KIRKLEES METROPOLITAN COUNCIL INVESTMENT & REGENERATION SERVICE

DELEGATED DECISION TO DETERMINE PLANNING APPLICATIONS

Reference No:	2026/62/90035/W
Site Address:	4, Rushfield Vale, Fenay Bridge, Huddersfield, HD8 0BX
Description:	Erection of single storey rear extension and raised decking area
Recommending Officer:	Joanna Rednall

DECISION – CONDITIONAL FULL PERMISSION

TITLE
PLANNING_INFO

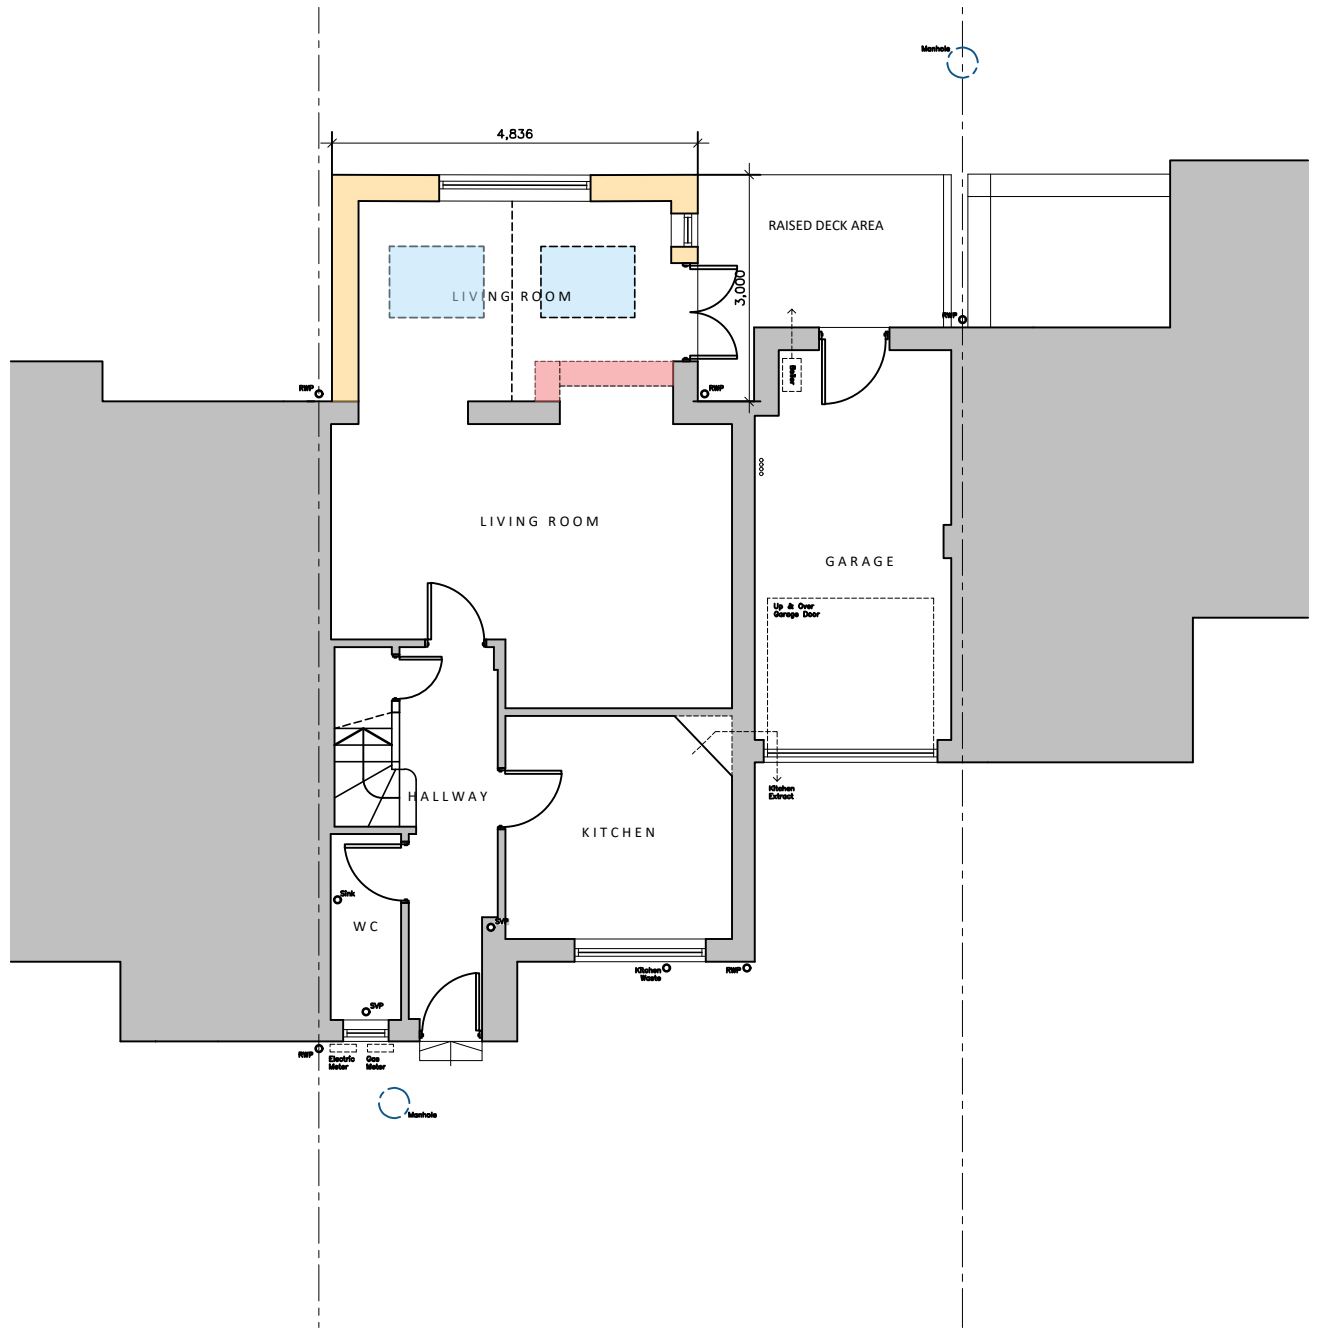
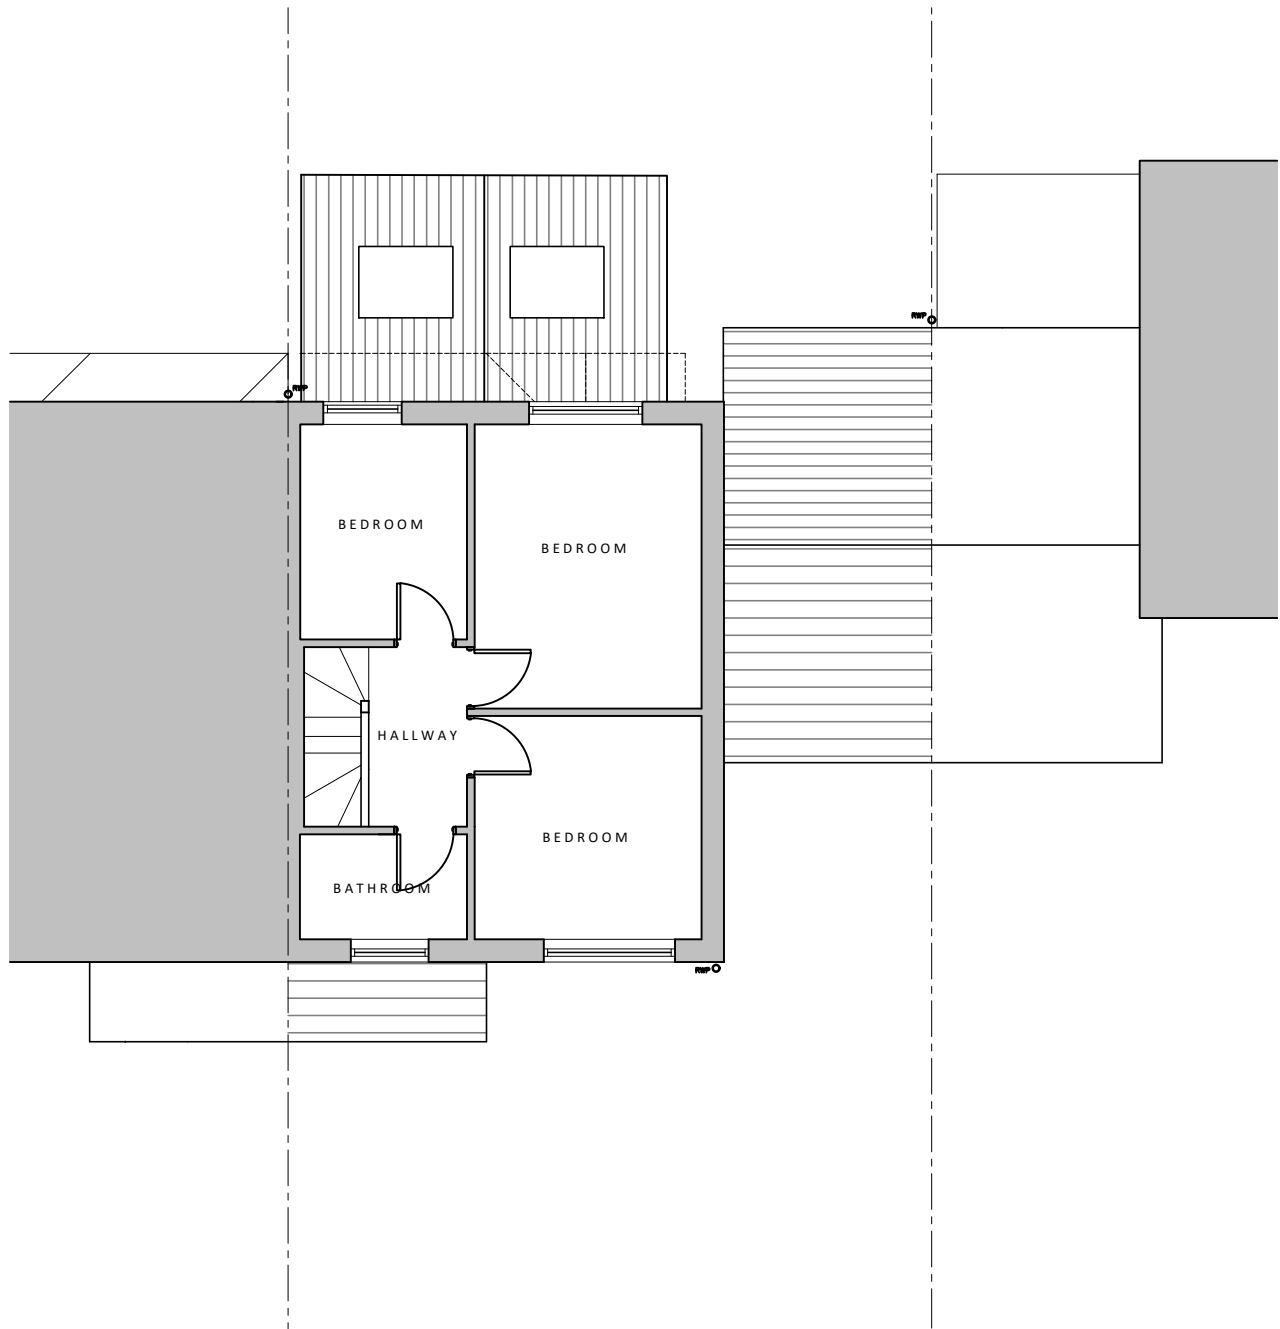
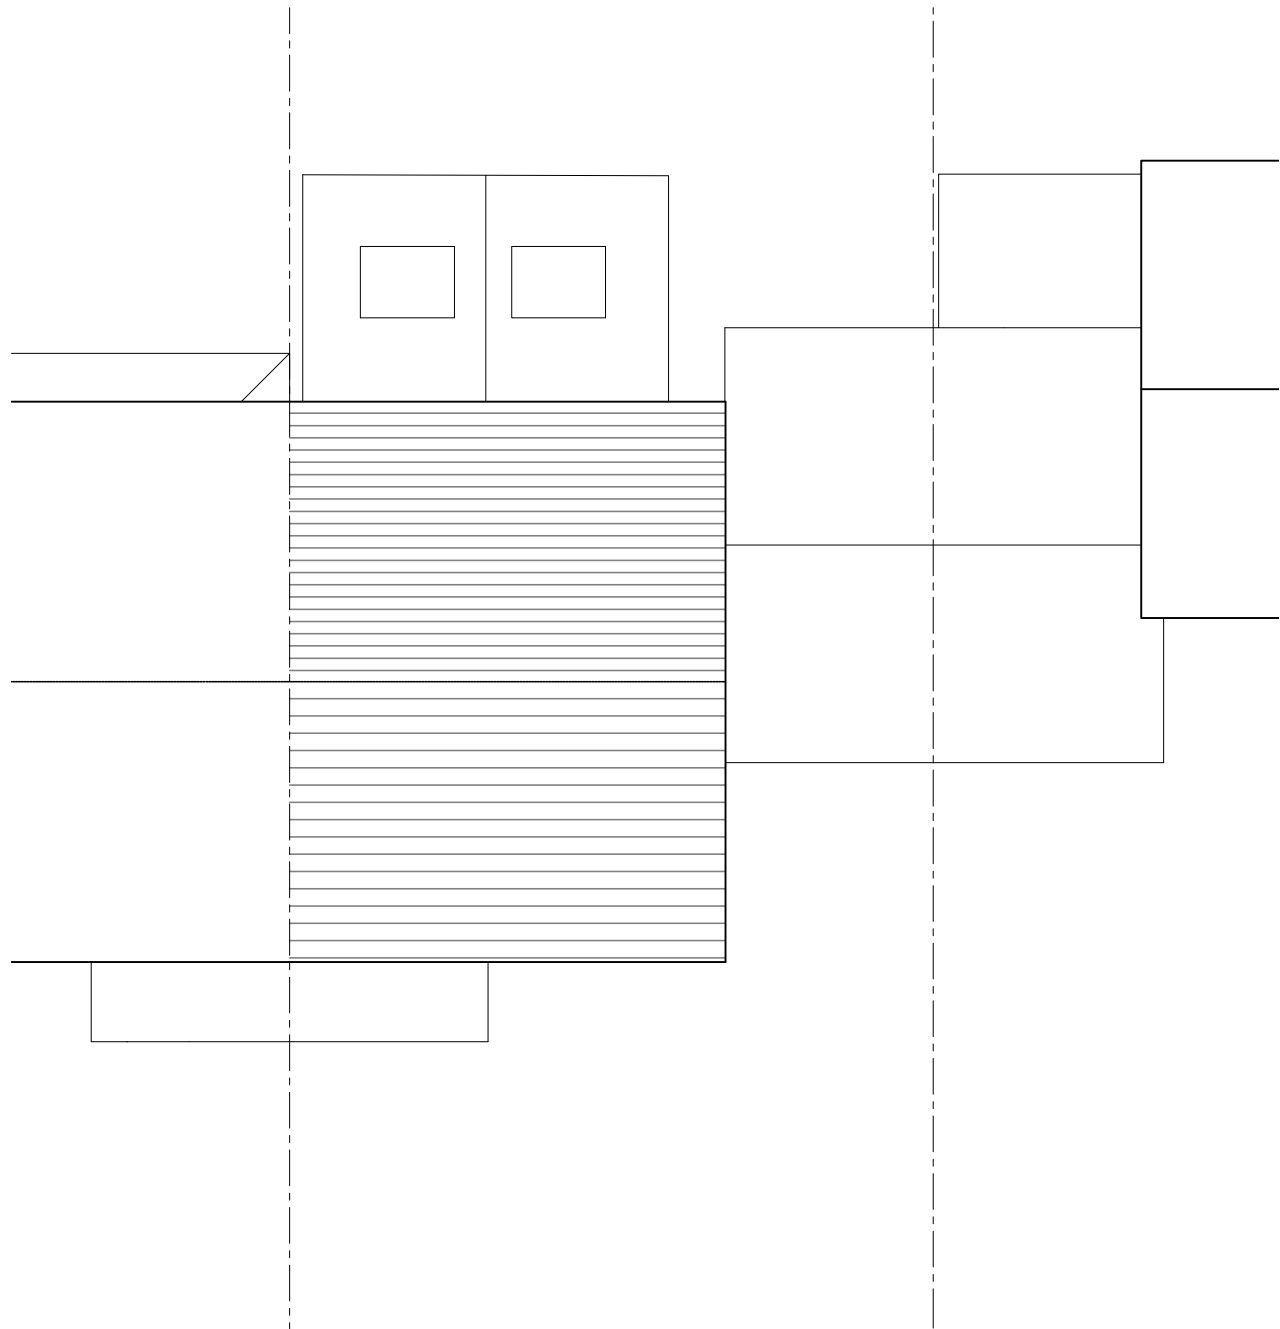
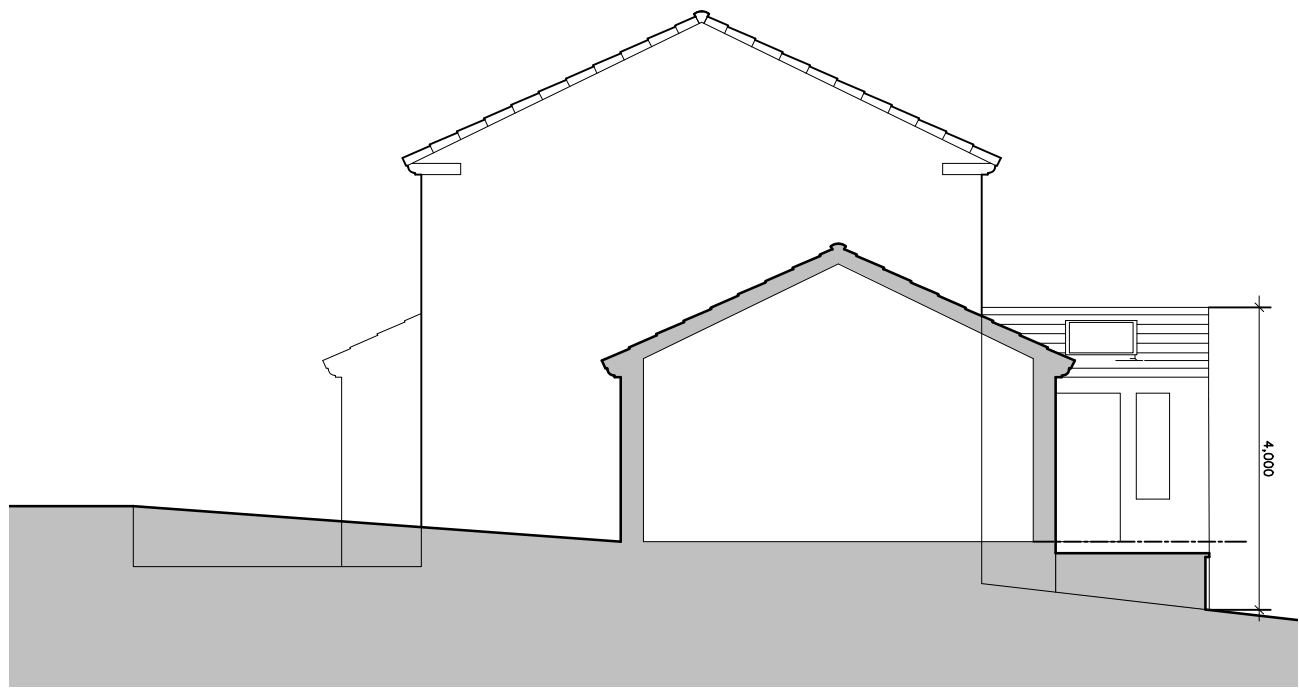
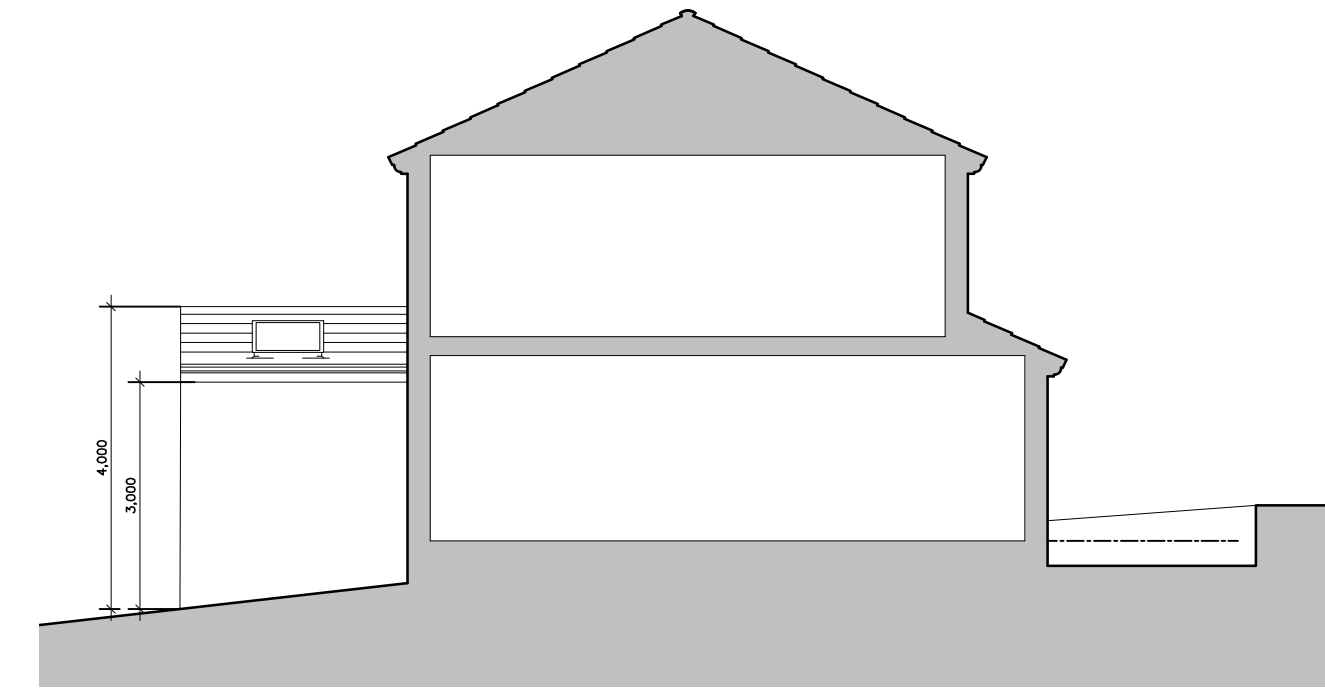
The proposed rear extension is considered to appropriately conform to the recommendations / principles as set out in the SPD. Although it has been acknowledged that the rear extension is not set 1 metre away from the neighbouring boundary to the south, with only a gap of 0.2 metres to be retained, as the side elevation of the building to be extended is sited along the shared boundary, it is considered there would be no design benefit in setting the extension in by a whole metre and it would be unreasonable of the LPA to request such an amendment in this case.

From a visual amenity perspective, the proposed single-storey rear extension at 4 Rushfield Vale is considered to read as a subservient addition that accords with the size and scale guidance set out in the SPD. Although positioned to the rear, this elevation is visually prominent due to its elevated setting and its relationship with Fenay Bridge Road. Even so, officers consider that the proposal's sympathetic design, including the use of materials that match the host dwelling and fenestration that reflects the original architectural style on both the rear and side elevations, ensures the character of the dwelling is preserved and the extension would not result in an obtrusive addition that harms the character of the area. The projection would lie flush with the rear elevation of the adjoining neighbour No.2, therefore it would not encroach beyond the existing building line fronting Fenay Bridge Road. The pitched roof form further reinforces consistency with the design of the existing house.

The raised decking forms a modest and subordinate addition to the rear of the property. It sits between the proposed rear extension and the neighbouring porch to the north, being 0.6 m above ground level and enclosed on its northern edge by a 1.8 m boundary fence. The decking does not extend beyond the rear elevation of the extension, ensuring it remains contained within the established rear building line fronting Fenay Bridge Road. Taken together, these factors mean the structure reads as a modest, domestic feature rather than a visually prominent or intrusive element. Its limited height and restricted footprint in relation to the host dwelling ensure that it does not compete with or overwhelm the original building. Because it is set well back from the public realm and screened from the highway, it avoids any material impact on the street scene or the wider character of the area.

The decking would sit directly alongside the neighbours boundary, with the rear extension itself positioned a further 3.2 m away. A 1.8 m boundary fence is proposed along the northern edge of the decking to provide effective screening. Although an existing hedge currently separates the porch from the application site, the plans indicate this would be removed to facilitate the development. Its removal does not significantly alter the relationship between the two properties, as the replacement boundary treatment would provide a comparable level of screening. The introduction of a solid 1.8 m screen fence in this location is not considered to harm the living conditions of the occupants of No. 2 given the main outlook is to the west and the screen fence does not protrude beyond the western elevation of no.2. The decking itself is modest in scale, being 0.6 m above ground level, and the extension is set back sufficiently to avoid creating any sense of enclosure.

The extension projects 3m along the shared boundary. The siting of this is adjacent to adjoining neighbour, and would be adjacent to patio doors which form a main habitable opening. The proposal would lead to a level of impact to this ground floor opening.

The orientation of the site is such that the overshadowing impact is lessened with the proposal being sited north of the patio door, furthermore the level of projection and size of the opening it is adjacent to within no.6 is such that it is concluded that whilst a 45 degree line would be cut by the proposal (with approx. 1.4m of the side elevation in place beyond the point it is cut) it is considered this would not be of such a significant extent that refusal on the basis of overshadowing could be substantiated in this case when considering the orientation of the site and scale and design of the proposal. The eaves level of the proposal would be at a height whereby they are at the same level as the top of the patio door, and the roof slope moving away from the shared boundary. In this context the extent of built form is not considered to unacceptably overshadow the neighbouring occupier and would not be unduly oppressive / overbearing.
